Freedom Forever
Planset Revision Letter

6/19/2023
REV #1

TROY HARRIS
132 COOPER CREEK AVENUE, SPRING LAKE, NC 28390

ROOF MOUNT PHOTOVOLTAIC SYSTEM

SITE PLAN			
JOB NO:	DATE:	DESIGNED BY:	SHEET:
337821	5/27/2023	A.A.	PV-2

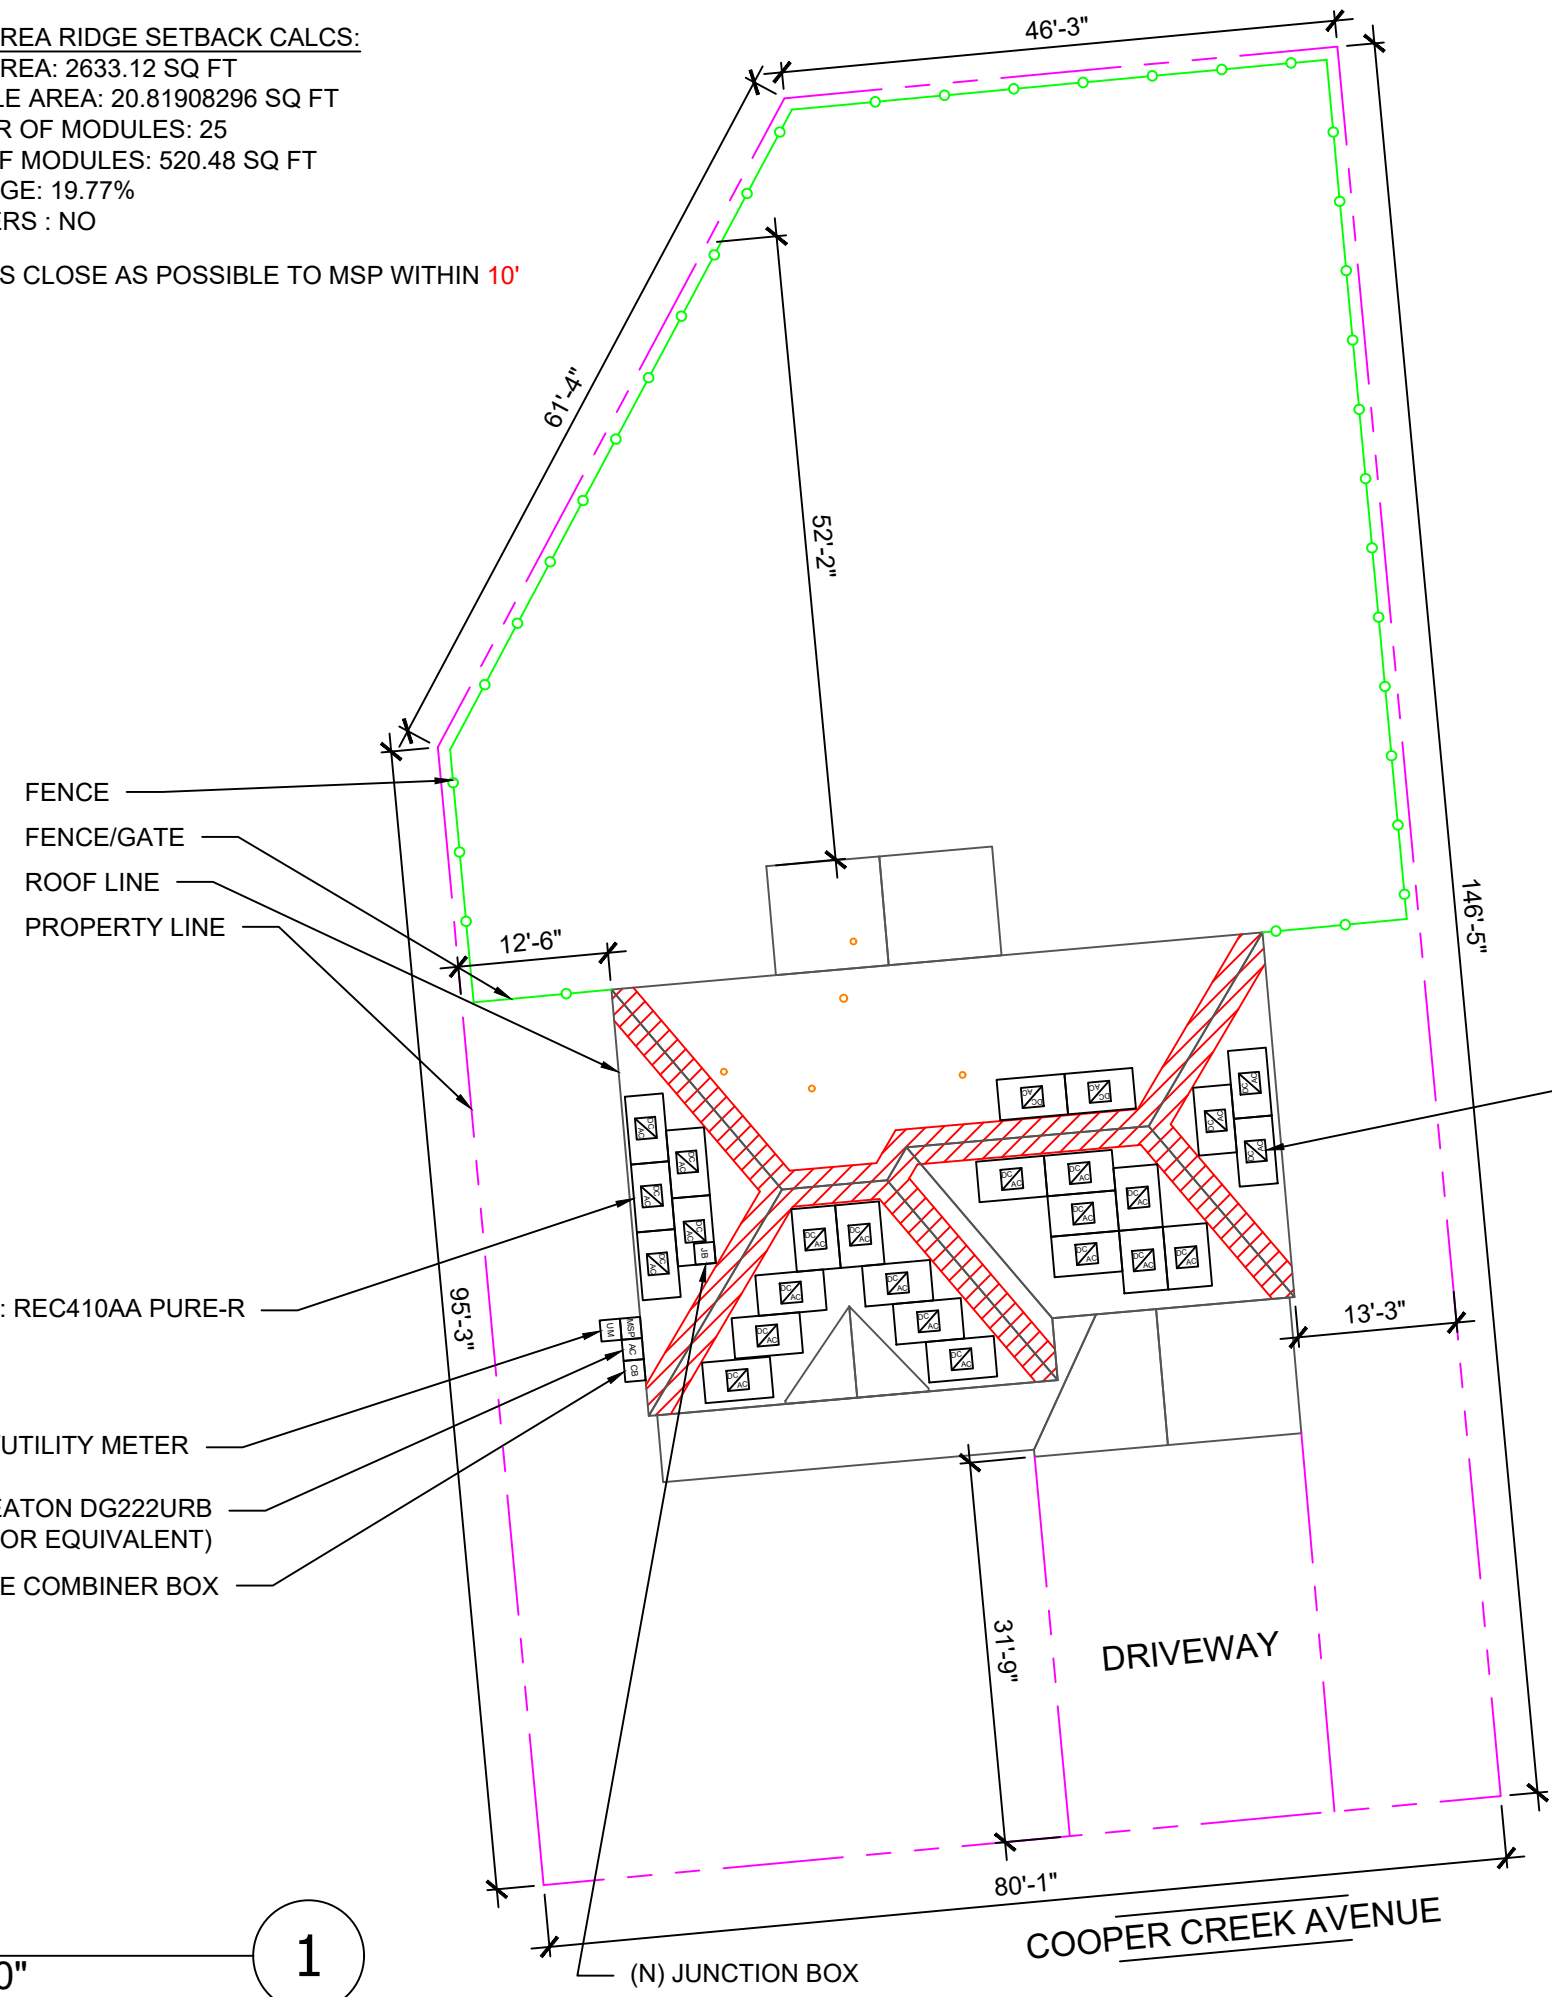
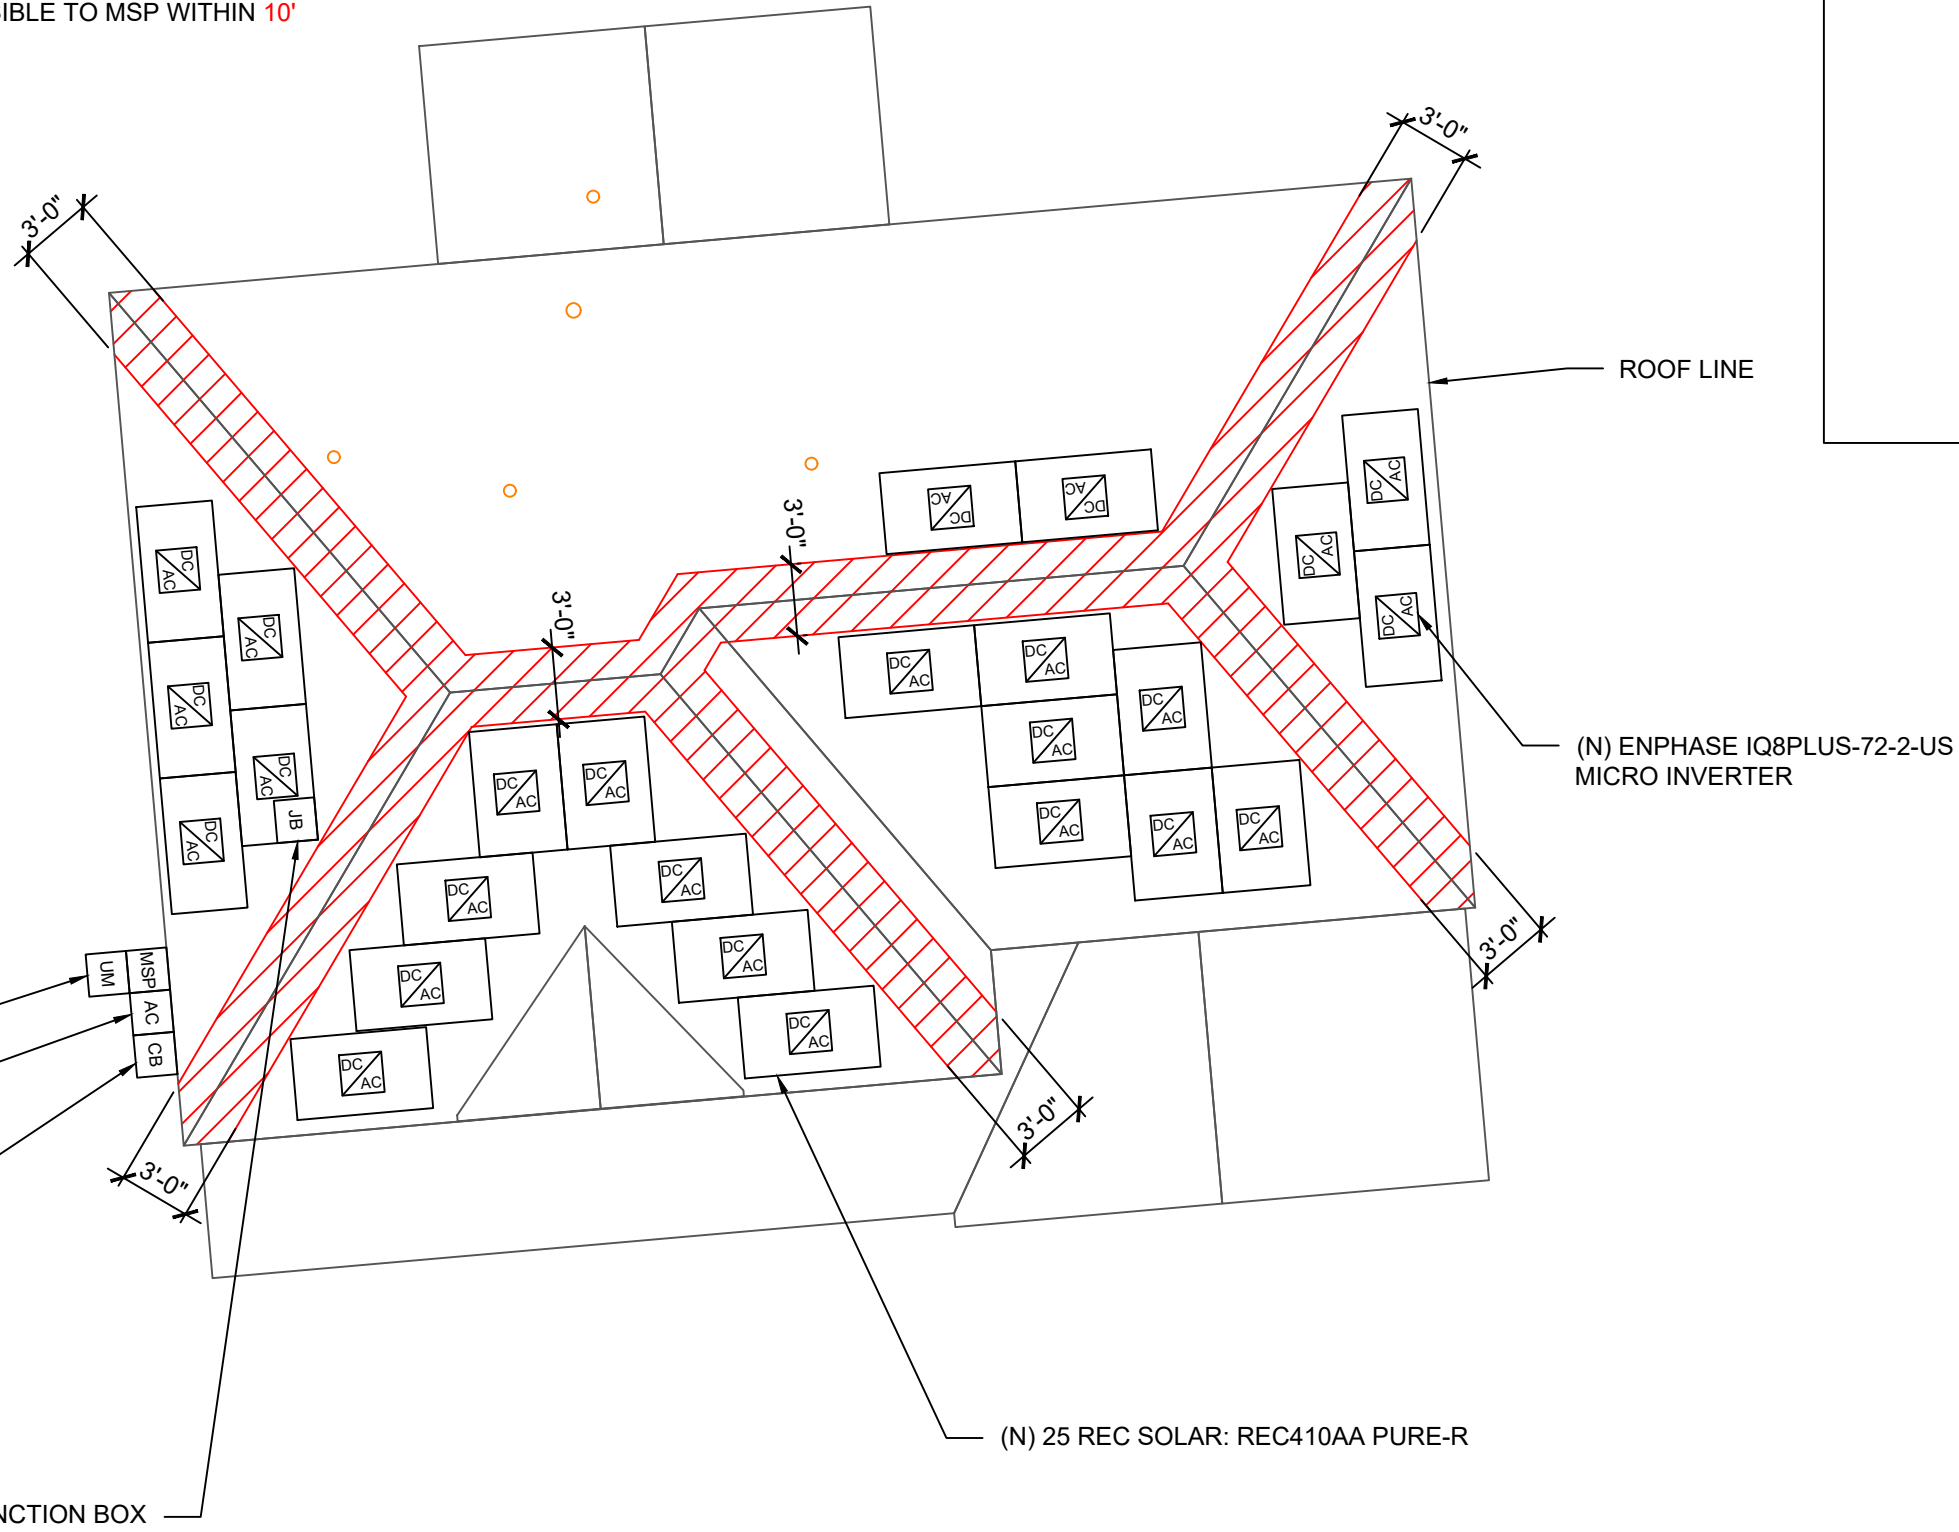
1. Switch from 25 X REC SOLAR: REC410AA PURE-R to 26 Candian 395W. New system size: 10,270 W.
2. Changed layout for new modules position.
